From: Fiona Fitzgerald <Fiona.Fitzgerald@arun.gov.uk>
Sent: 08 July 2020 16:33
To: Planning.Responses <Planning.Responses@arun.gov.uk>
Cc: Raymond Cole <Raymond.Cole@arun.gov.uk>; Neil Williamson <Neil.Williamson@arun.gov.uk>
Subject: FW: F/4/20/OUT

Environmental Health **objects** to this application on the basis of noise and odour.

Figure 3: Potential noise sensitive areas

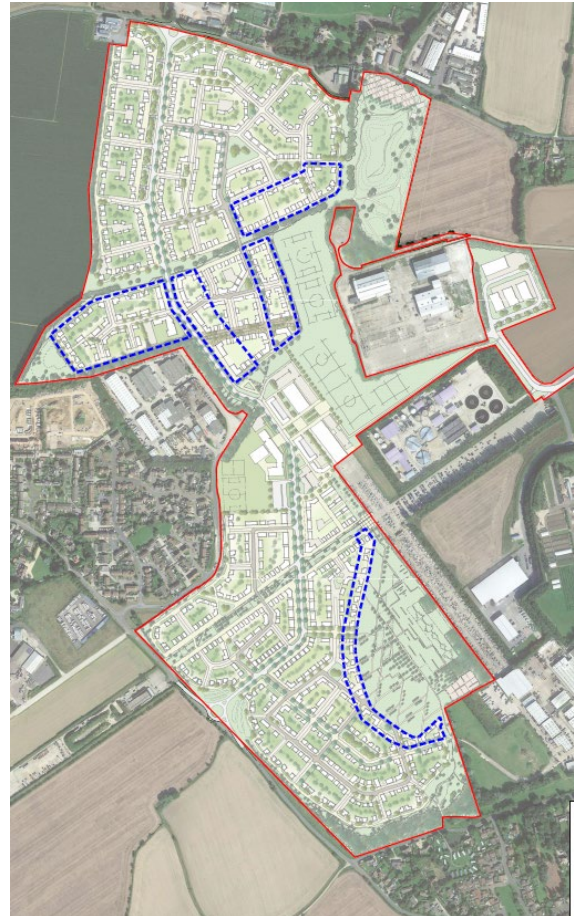
7. Paragraph 5.15 states “it should be noted that some dwellings will require closed windows to achieve suitable internal noise levels”. Please could the applicant provide further information on how many dwellings this is likely to apply to and their likely location?
